Letter No. **A1/8511/91**

Sub: MMDA - Planning Permission -

**Construction of residential building
in Plot No.10 at S.No.241/4 of
Madippakam village - Approved -
Regarding.**

Key plan NO.10 SCALE

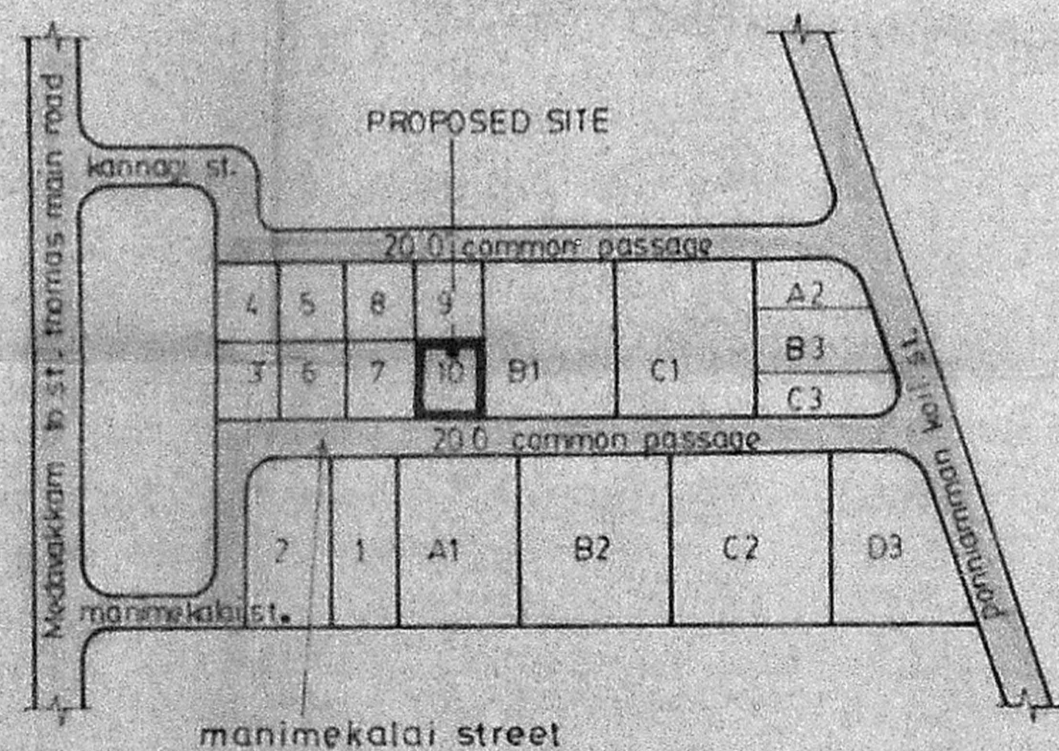
**You are also requested to furnish 5 sets of
revised plan incorporating the street name in the key plan & in
the title.**
